Our Ref: R/2016/1/D
File No: MP 08_0098 MOD 13

The Star (MP08_0098 MOD 13) – 20-80 Pyrmont Street, Pyrmont – Response to Submissions

The City of Sydney (the City) has reviewed the RTS and maintains its **objection** as the issues raised in the City's letter dated 9 October 2018 remain unaddressed. The following additional comments are provided for your consideration:

DRAWING NO.
L901

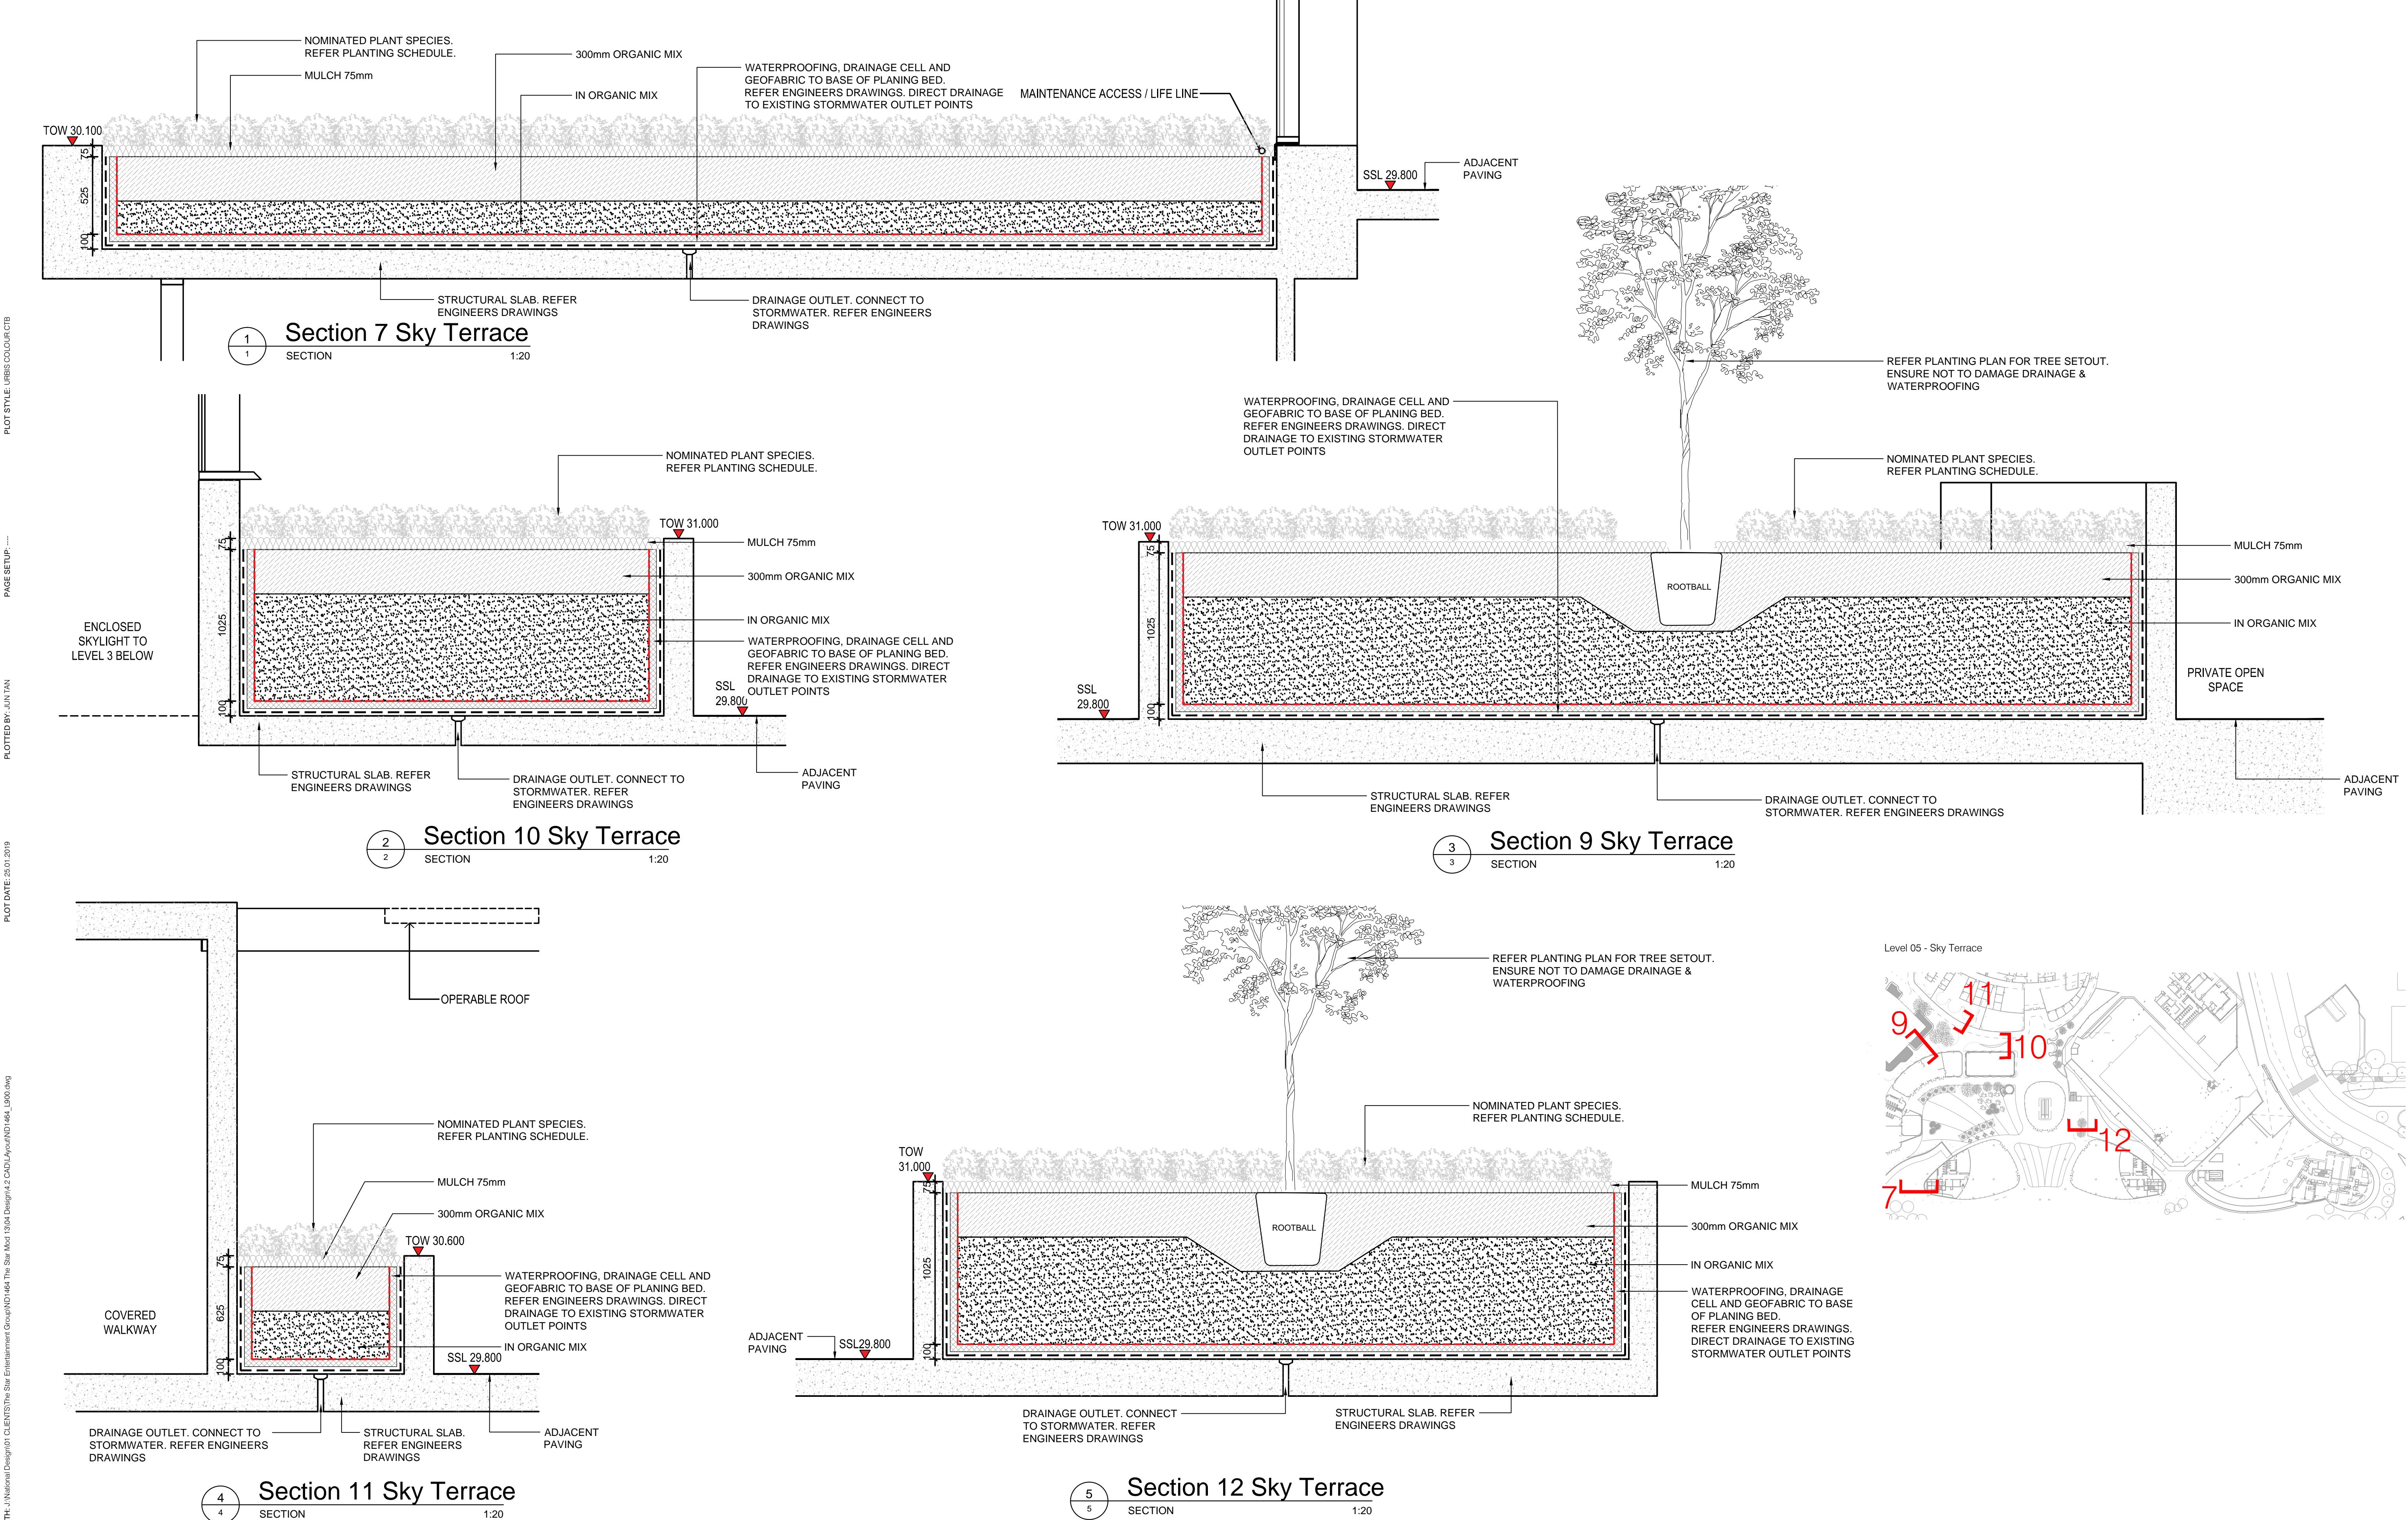
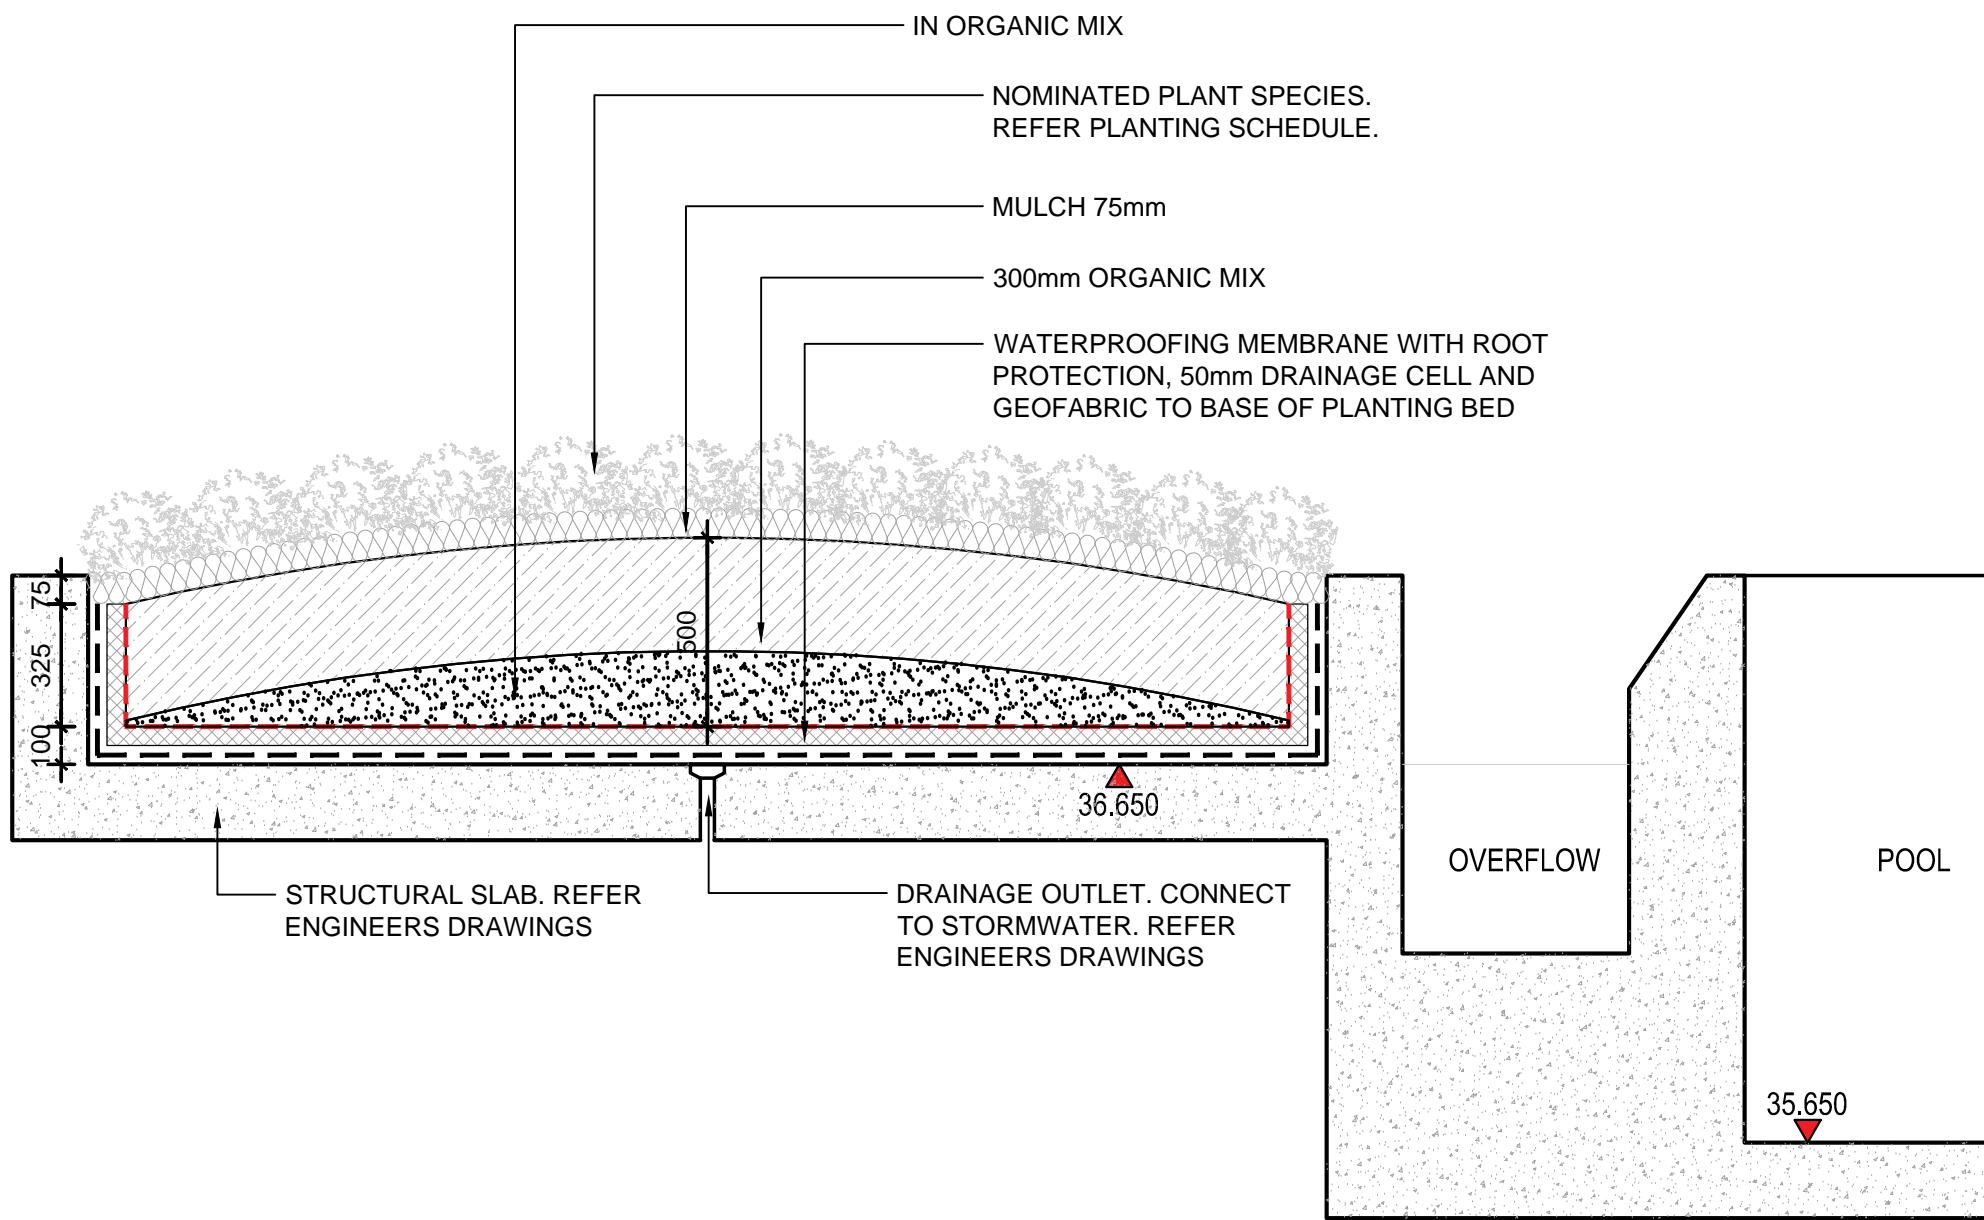
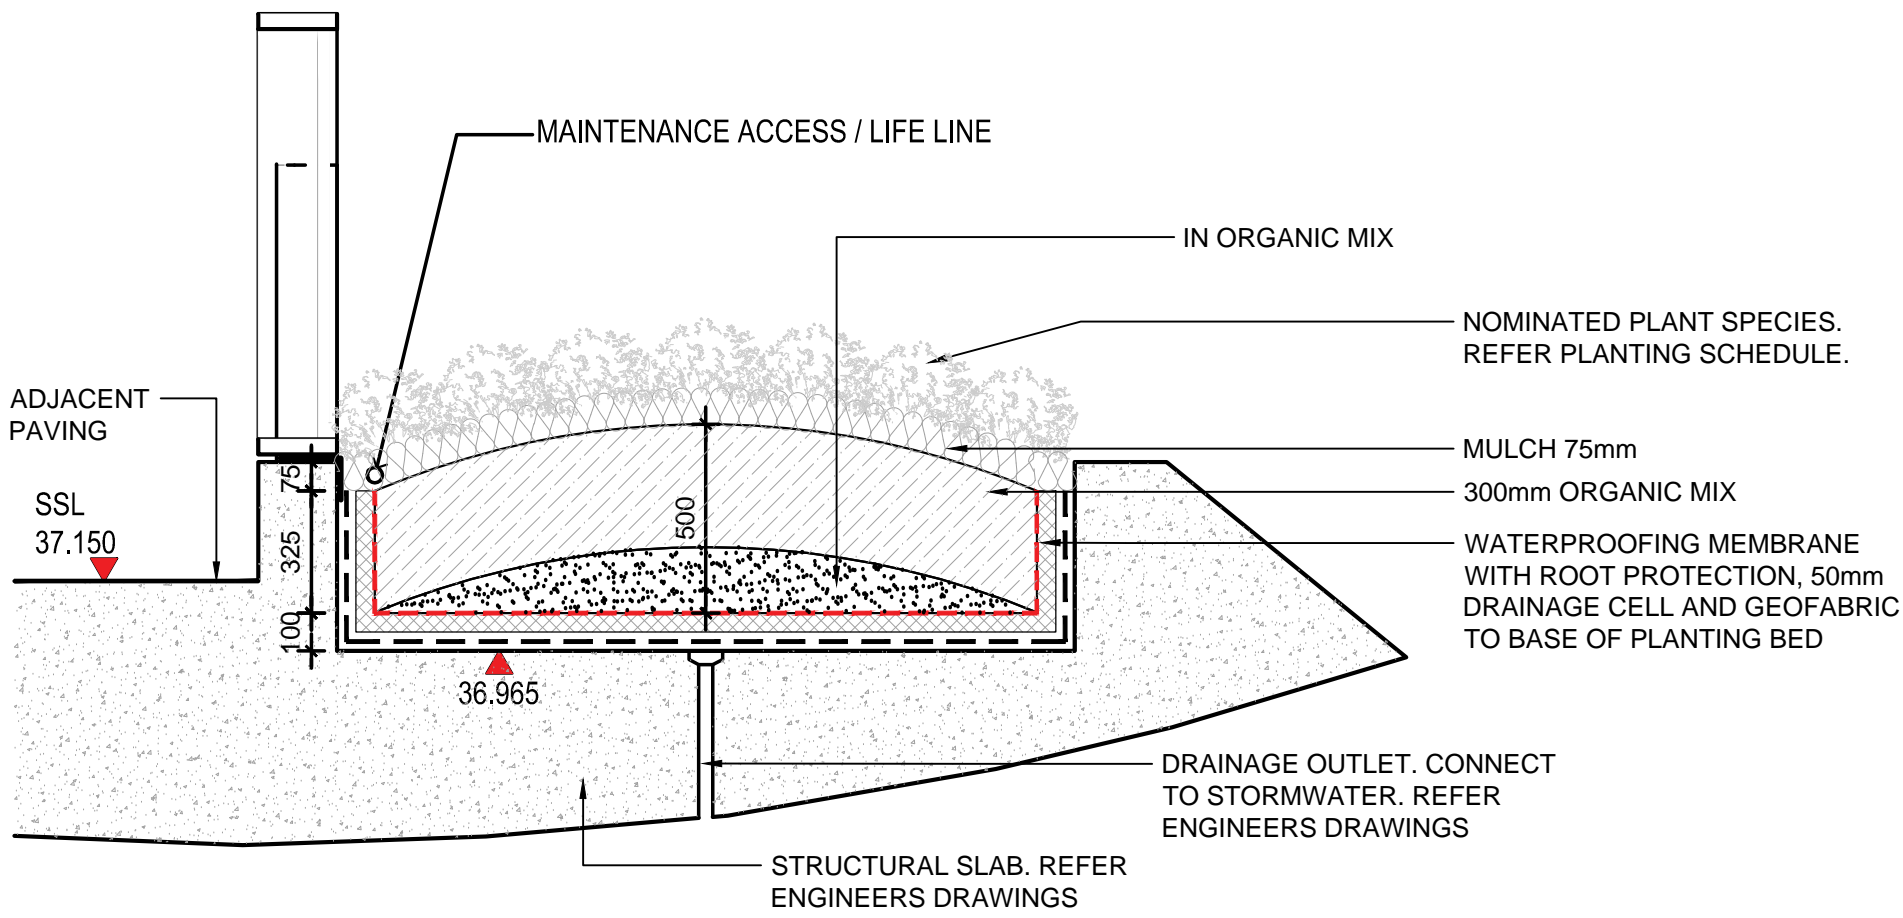
The applicant has confirmed minimum soil depths will be in accordance with the Landscape Code Volume 2 and the ADG as noted in table below, which is supported. However, several typical planter sections for planting on podium shown on Dwgs L900-902 [A], do not reflect the minimum depths which is not supported.

It is recommended that the landscape design should ensure that minimum soil depths (or higher) are achieved to ensure a high quality landscape outcome. It is noted that the minimum soil depths are in addition to drainage and mulch layers.
